**Response to Submissions
Residential development at 1 & 2 Murray Rose Avenue,
Sydney Olympic Park (SSD 9403)**

Alix Carpenter
**Senior Manager
Planning**

Title
31-HEIGHT CONTROL
HEIGHT CONTROL ANALYSIS

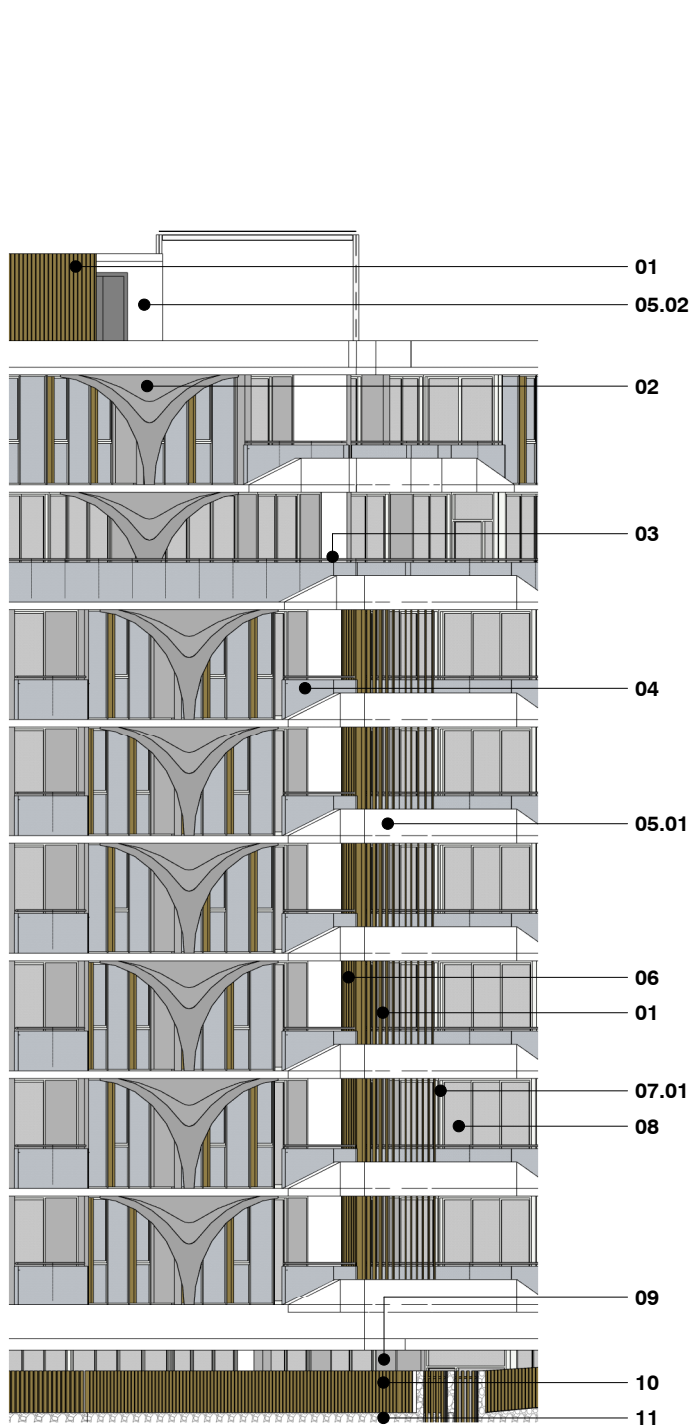
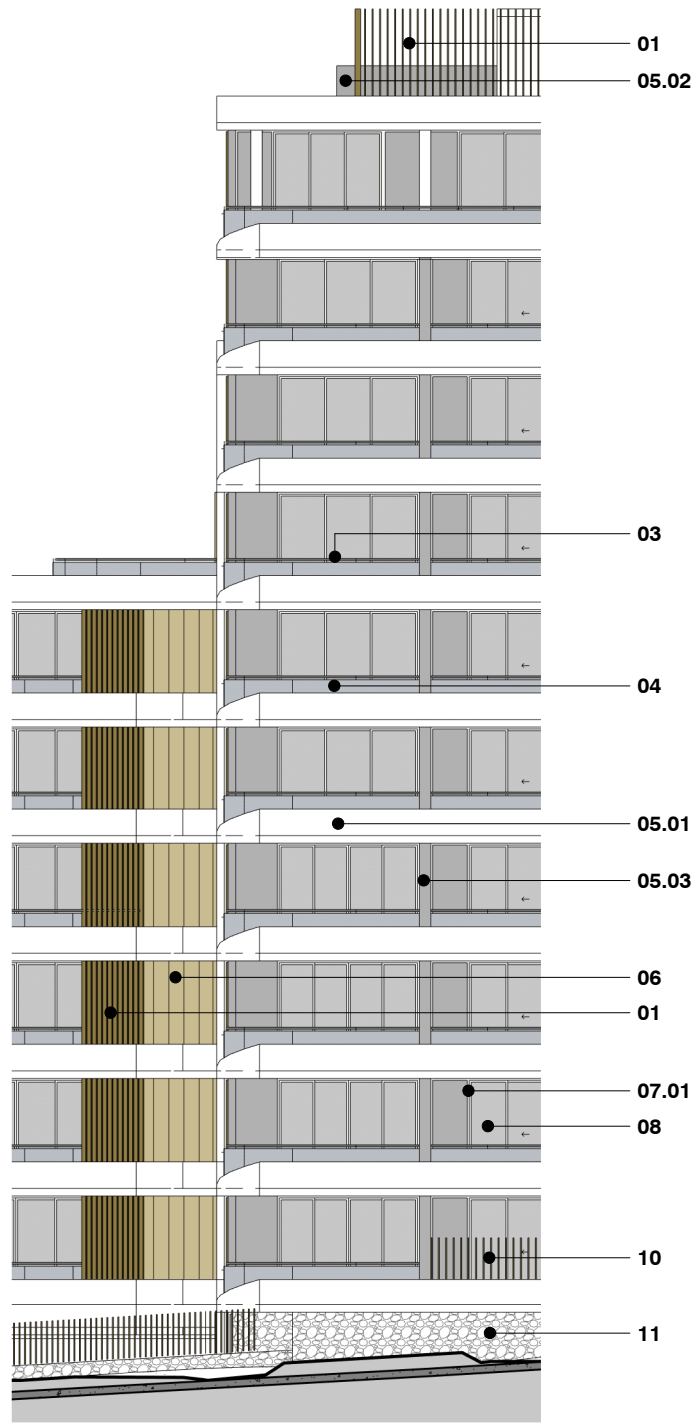
SOPA's primary concern with regard to building heights in excess of the maximum height controls under the SEPP SSP is its potential to increase overshadowing of the Badu Mangroves and wetlands on the eastern side of Bennelong Parkway. In this instance, the

overshadowing impacts of the proposed development are no worse than the expected impacts from a fully compliant building envelope.

SOPA's Ecology team reviewed the shadow studies and ecological assessment provided as appendices to the Environmental Impact Statement and raised no issues with the proposed height of either building or their potential overshadowing impacts.

SOPA also notes that the Design Competition Jury preferred the current design to a design that was compliant with the maximum height controls in the SEPP SSP, partly due to the improved amenity that this design would afford future residents.

Title
91-AREAS
GFA DIAGRAMS

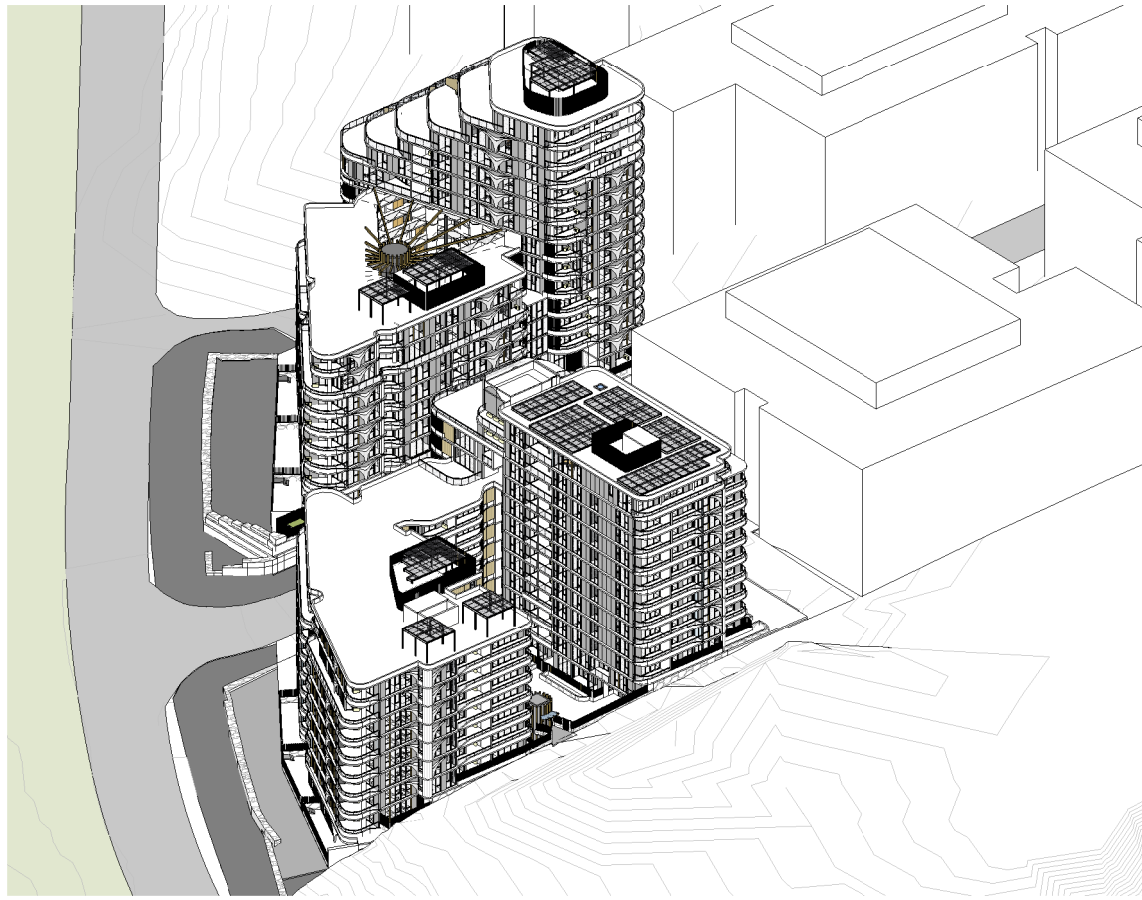
Development at 3, 4 and 5 Murray Rose Avenue has delivered a cumulative gross floor area of 43,457m². Based on a superlot area of 24,515m², the residual gross floor area for the superlot is 30,088m². The proposed development seeks consent for a gross floor area of 27,395m², which is 2,693m² less than the residual gross floor area permitted under the Master Plan.

SOPA therefore considers the proposed gross floor to be consistent with the Master Plan controls despite the non-compliance of the development with the maximum FSR controls under the SEPP (State Significant Precincts) 2005 (SEPP SSP).
